# City of Albuquerque Stormwater Construction Site Inspection Report

ESC File No.	R16E003C	Project Name:	Montage Unit 6		
NPDES Id. No.	NMR10064U	Location:	Bobby Foster and University		
3/24/2025	Owner	Contractor			
Operator	MDS Investments LLC	Guzman			
Contact name & title	Tom Schmidt	Eddie Gonzales			
	<a href="mailto:tom@SC3development.com">tom@SC3development.com</a>	<a href="mailto:eddie@guzmancs.com">eddie@guzmancs.com</a>			
Contact Phone #	505-238-0700	505-452-0663			
COA Inspector	Chancellor English	Start/End Time:	1230-130pm		
Construction Phase:	Grading, curbs				
Type of Inspection:	<b>Regular</b>	Storm Event	Past Storm Event >0.25"	311/Complaint	
Weather at time of inspection?		clear	Temperature: ~	65	
Estimated date of last storm 0.25" or greater		11/7/2024

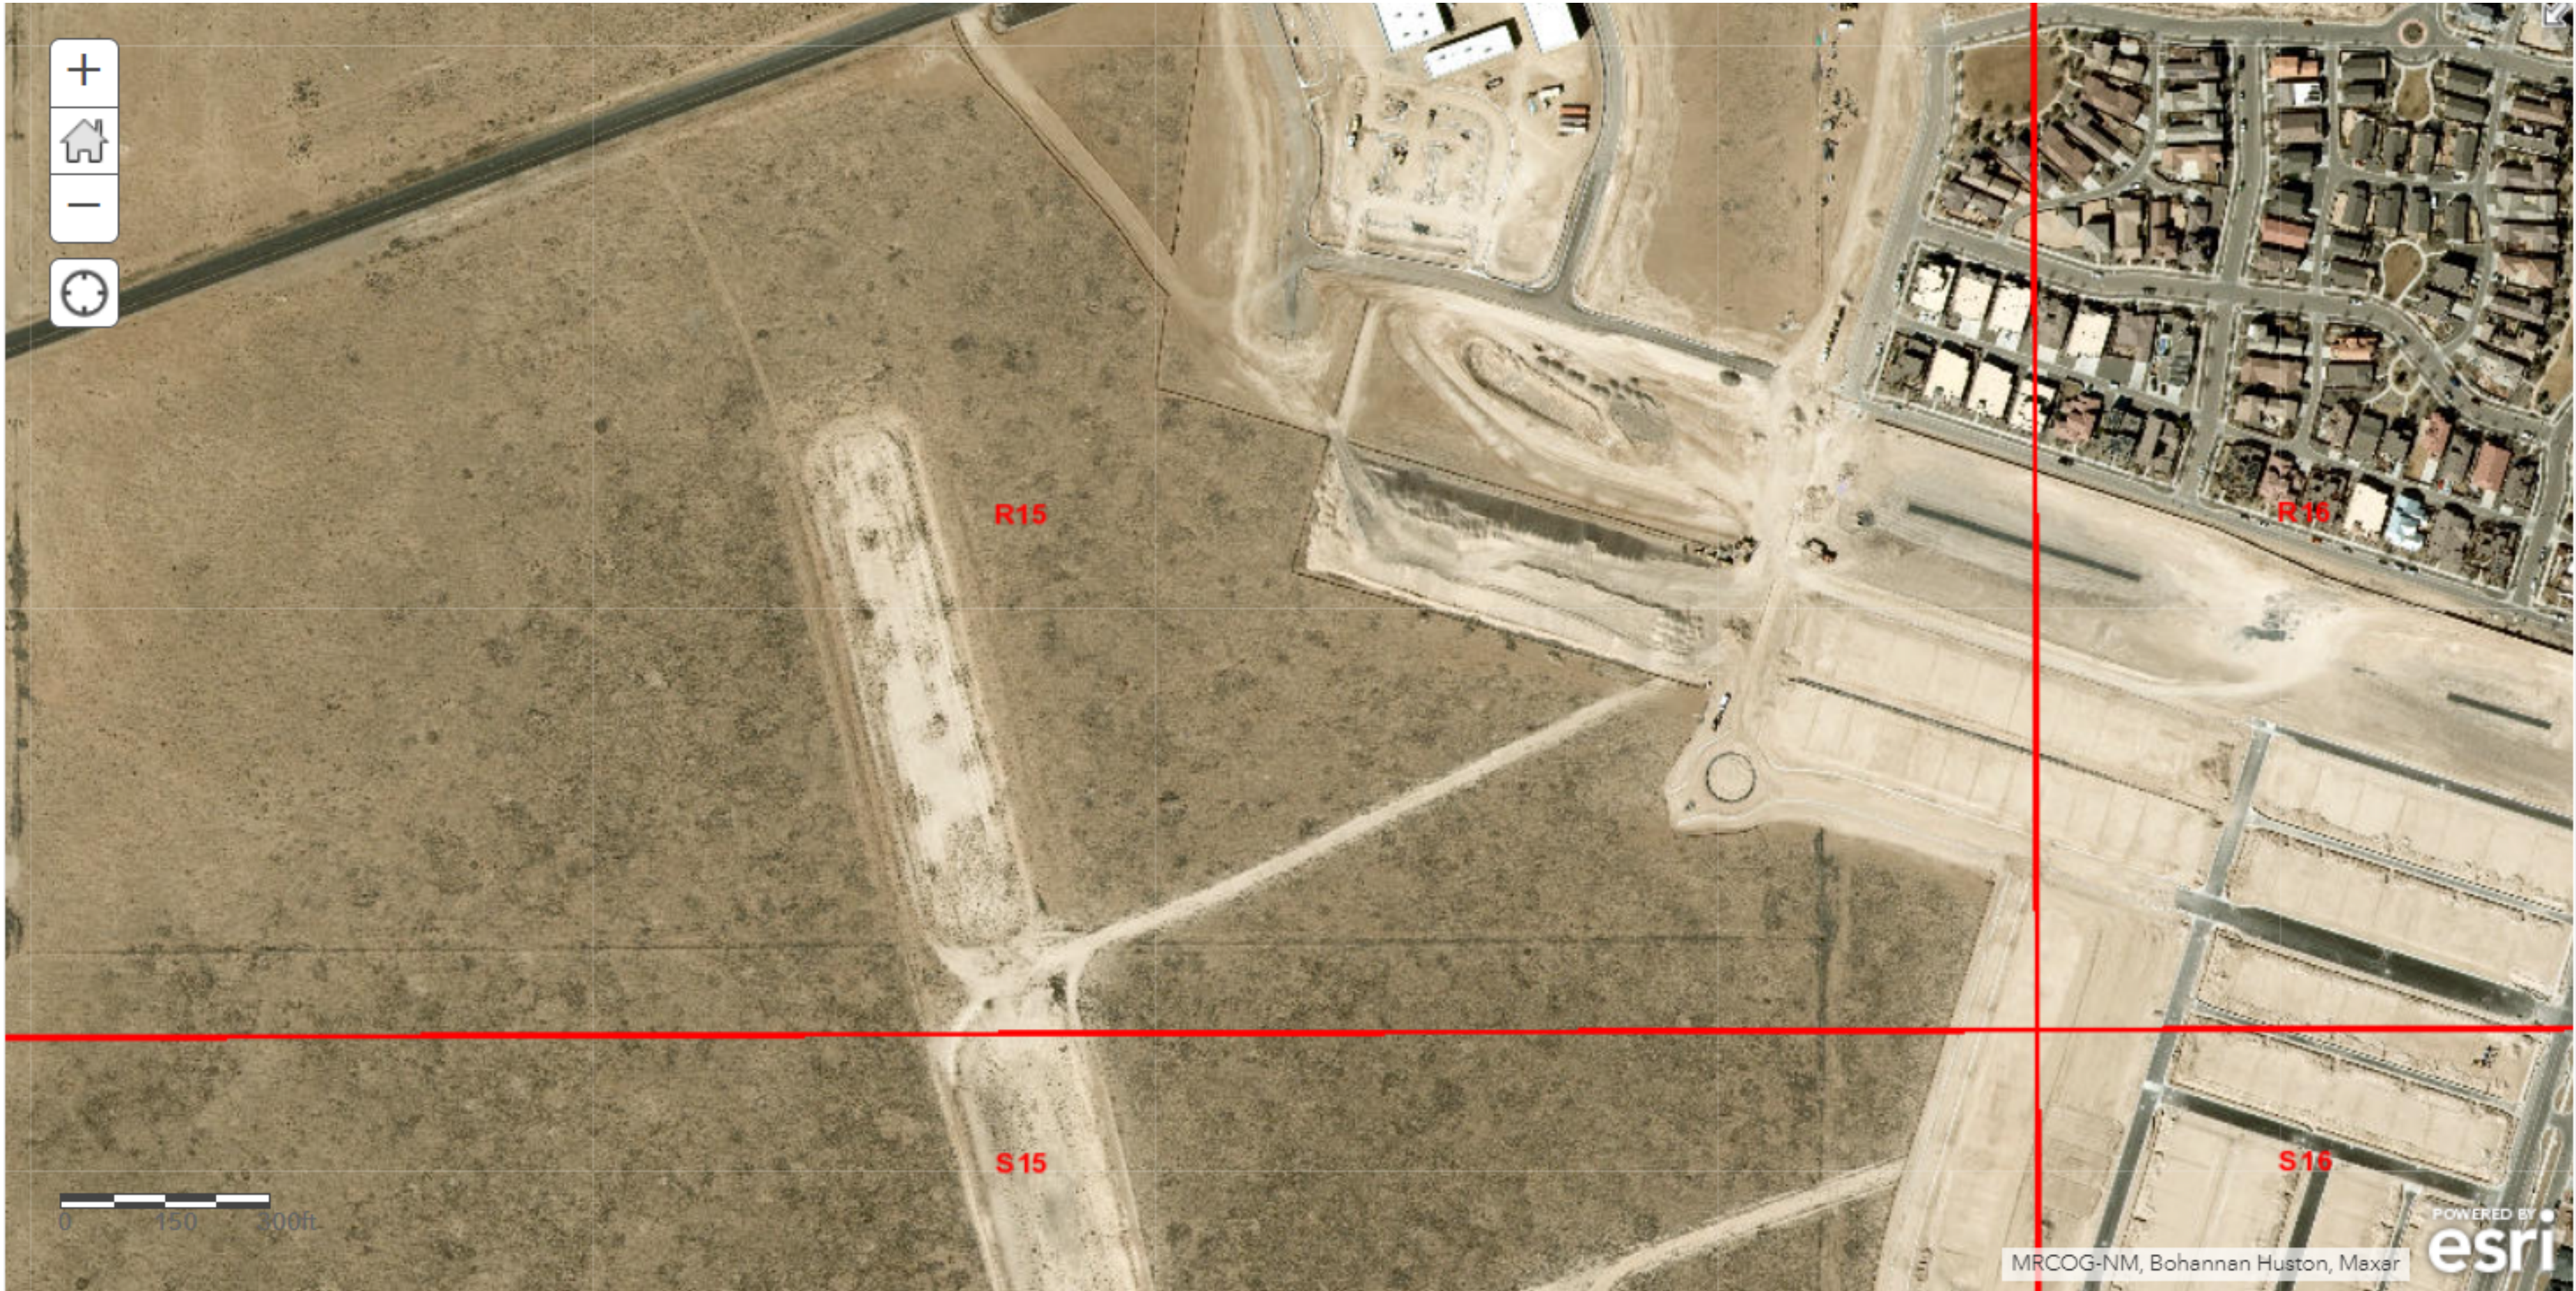
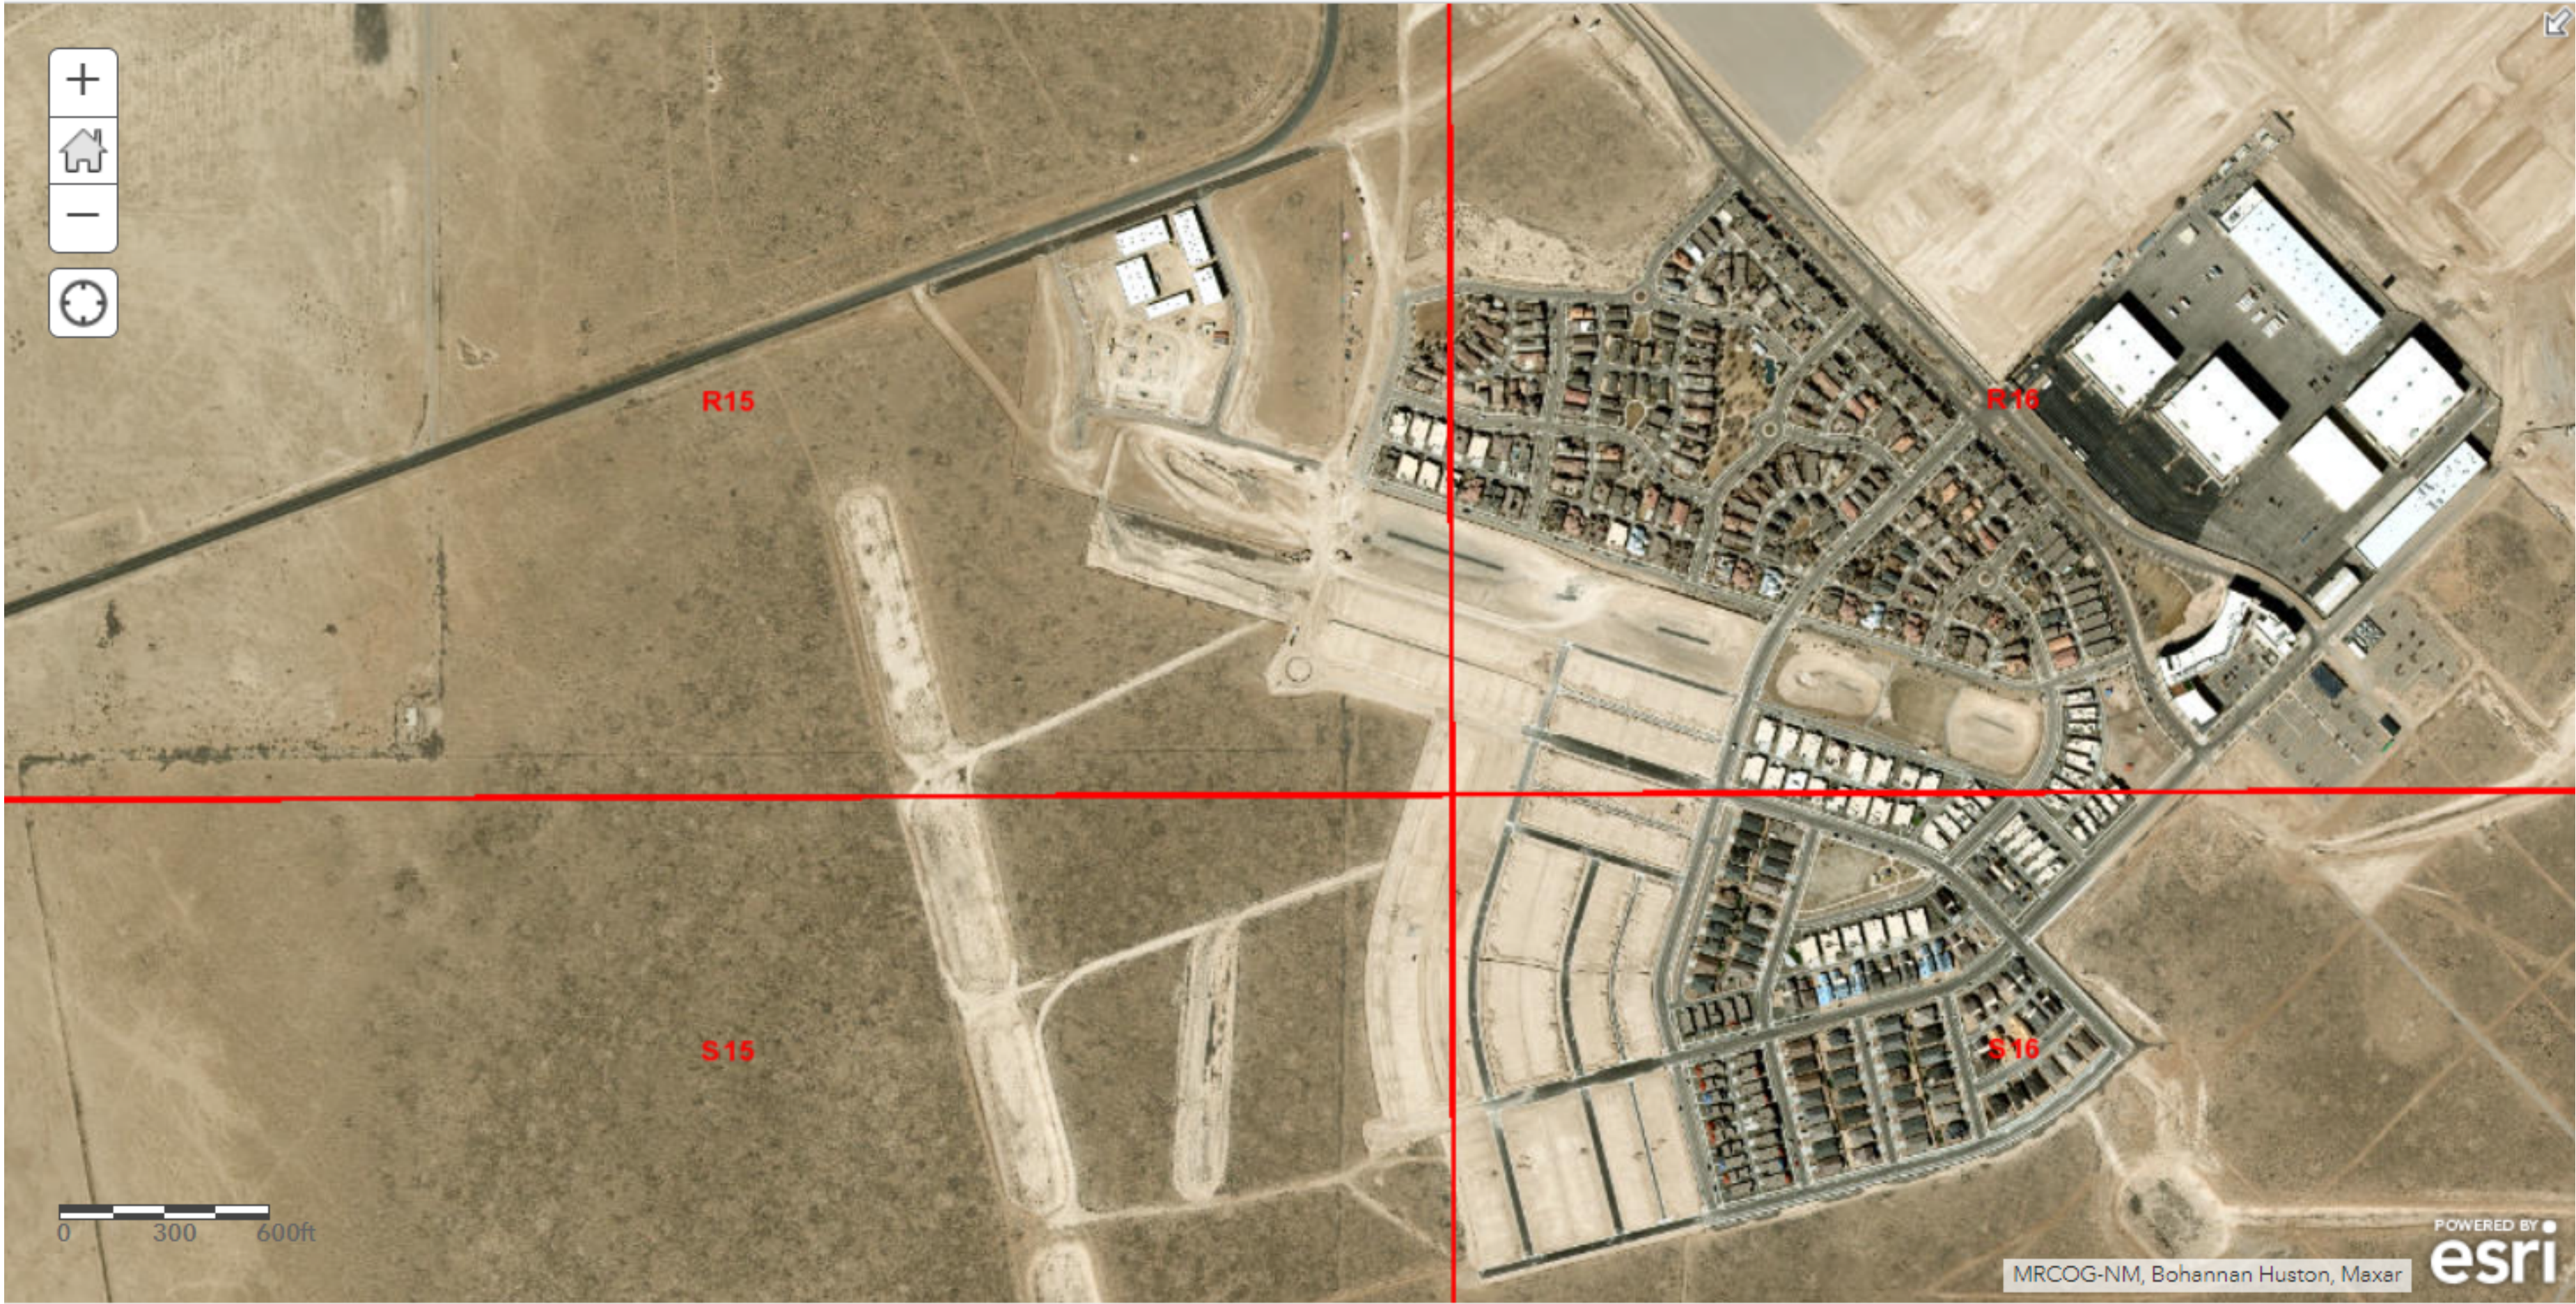
Item Number	Deficiency/ Corrective Action				
1	BMPs - The perimeter silt fencing needs to be reset as it has collapsed in several areas in violation of CGP Part 2.1.4. Required mitigation: Ensure all stormwater controls are maintained and remain in effective operating condition during permit coverage and are protected from activities that would reduce their effectiveness per CGP Part 2.1.4.

Notes:	
Heavy Equipment is being stored on the MDS Investment Stockpile lot. If this equipment is related to the development of Montage Unit 6, either the SWPPP map will need to be amended to include the area used to store equipment or the equipment moved to your property. MDS Investment LLC has included their NOI in the SWPPP.	
The SWPPP is in a doc-box mounted on the back of the posting.
